11 February 2021

## Loreto Normanhurt – Response to Submissions – Agency

MARY WARD COURTYARD TREE RETENTION & REMOVAL PLAN

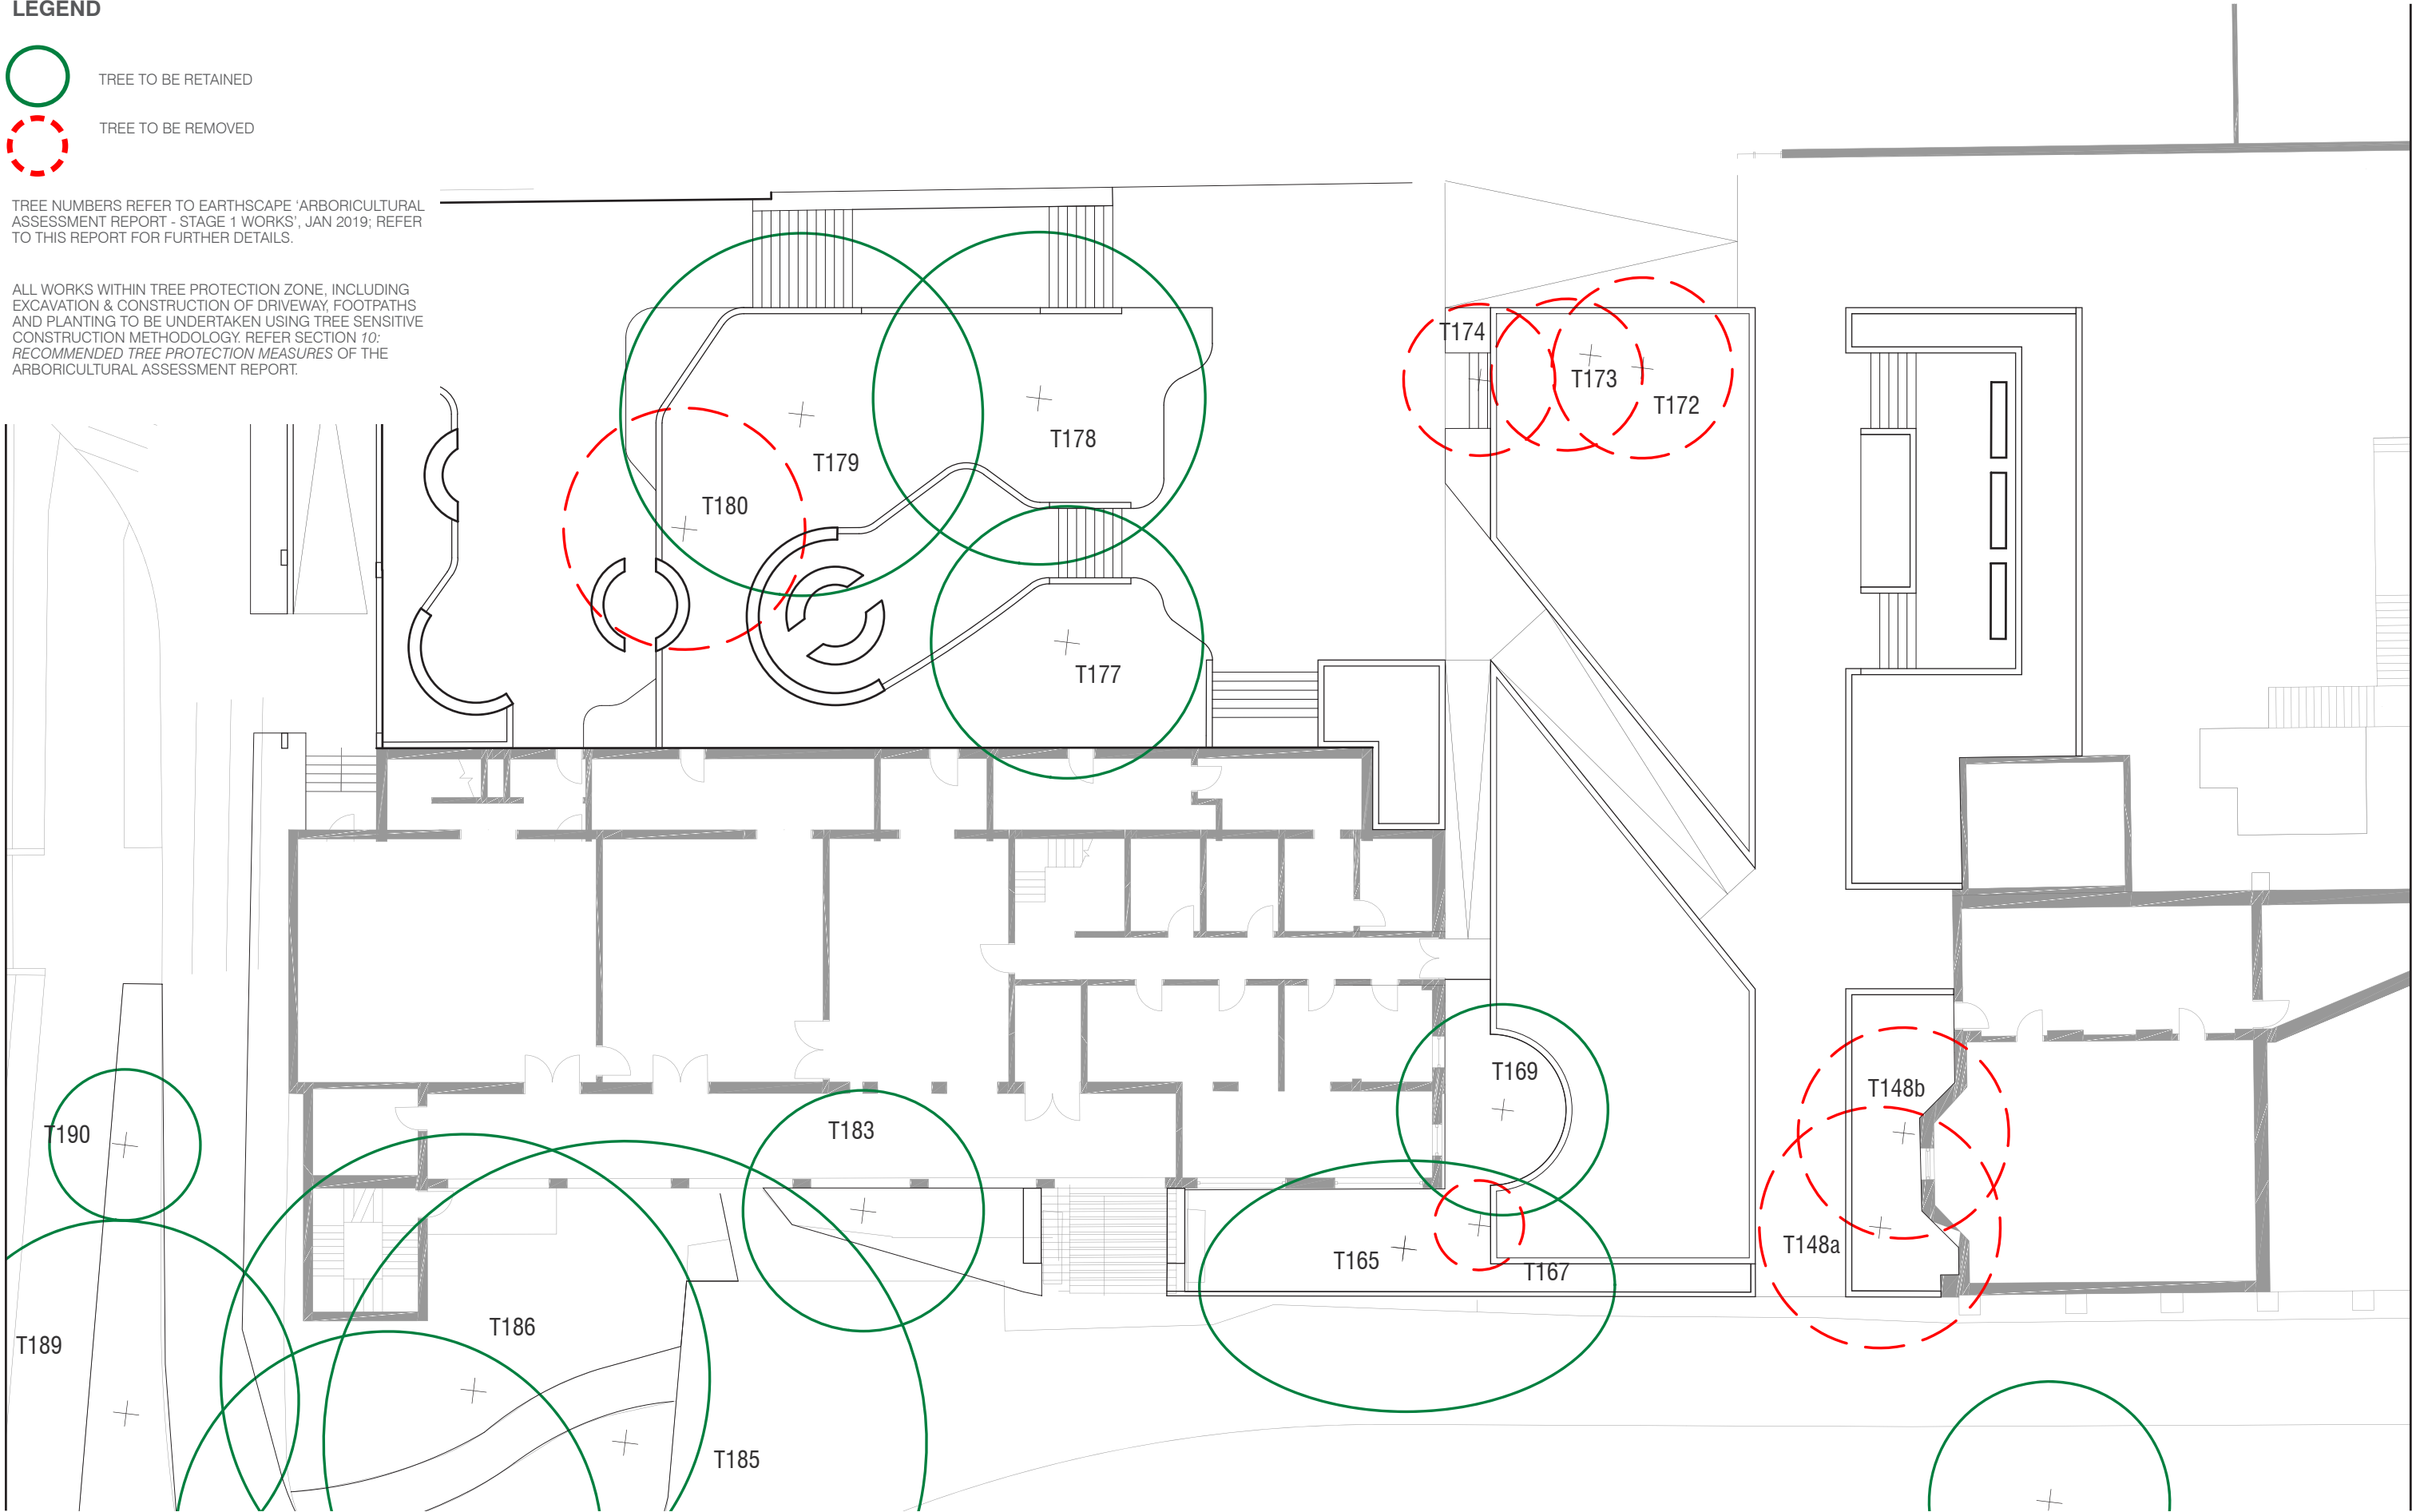
<p><u>Trees</u></p> <p>Council raises concerns with the loss of high retention value trees on the site.</p>	<p>The proposed development will necessitate the removal of ten (10) trees of high retention value. These trees have no special ecological or heritage significance, but are in good health and condition and make a positive contribution to the amenity of the site and streetscape. The building has been placed as best as possible to minimise loss of trees. There are no feasible options that can be recommended to preserve these trees in this instance given the extent of site development and the position of these trees within the site. In order to compensate for loss of amenity resulting from the removal of these trees to accommodate the proposed development, the school has committed to the replacement planting with new trees elsewhere within the site as a condition of consent.</p>
<p>The Traffic Assessment report (TAR) prepared by Asongroup needs to be updated to include the following: Existing pick up operation is to be reviewed and improved.</p>	<p>Since the original Transport Assessment Report, the existing pick up and drop off arrangement at Osborn Road has been reviewed in its current operation and for its adequacy for the future operations at the School. To address the pick up and drop off issues and future demands Loreto has proposed a relocation of the existing facility and an additional through site link to further increase on site capacity.</p>

BOARDING SCHOOL LANDSCAPE PLAN

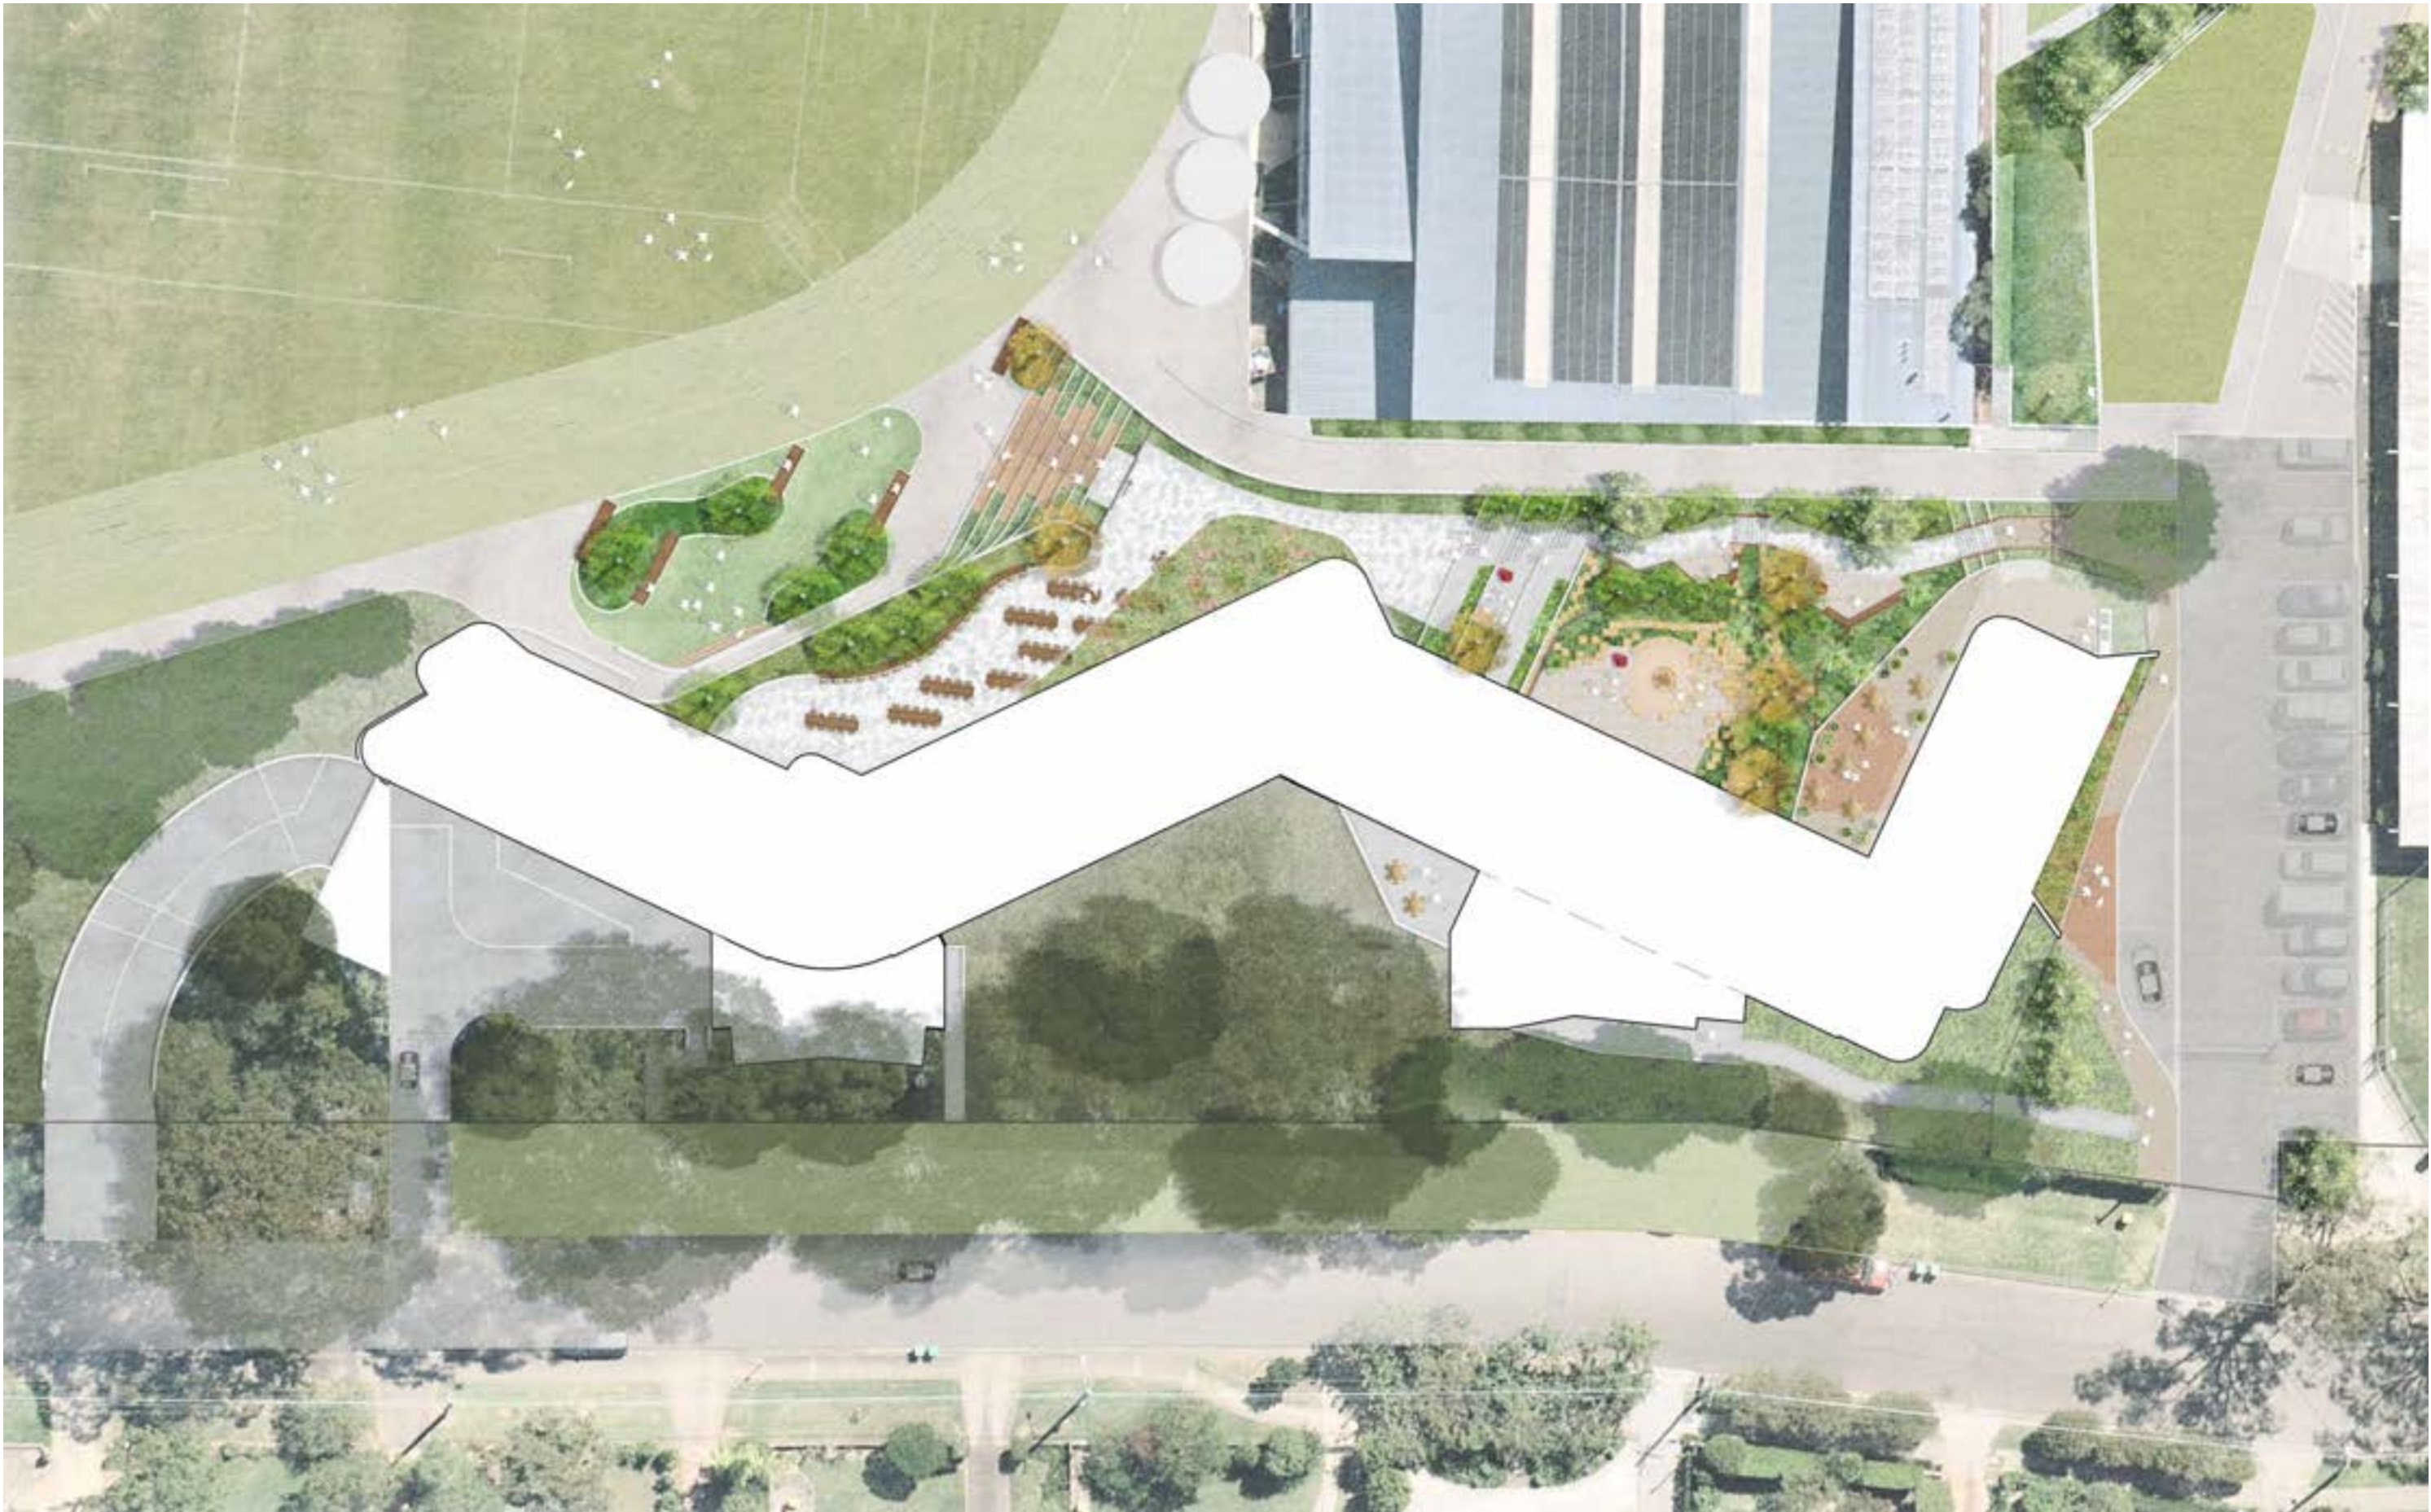
<p><u>Stage 1 Boarding House</u></p> <p>The landscape plan indicates that a large number of trees would be removed from the Mount Pleasant Avenue frontage to accommodate the boarding house. While the replacement planting plan includes a few large trees in the schedule (35m high), it does not specify the location of the planting (except a reference to broad zone 1).</p>	<p>A tree planting plan has been included in the boarding house report which allocates the tree species and locations with a commitment by the school to plant any additional trees required elsewhere around the campus. Tree species have been chosen to align with the Arborist report recommendations.</p>
<p>The front setback of this building is a minimum of 6m and no evidence is provided to demonstrate that this setback can accommodate the proposed tree canopies of species such as Spotted gum or Blackbutt. The planting plan must be revised to show the location of the plant species and the quantity that are proposed at each location. Screen planting must be an essential element to assist in reducing the impact on the adjoining residences of any development along this frontage. Consideration should be given to the adequacy of the building setback</p>	<p>A section has been included in the report to indicate the tree protection zone for the high significance tree in the setback. An updated Arborist report should be provided with regards to the architectural update to the building.</p>
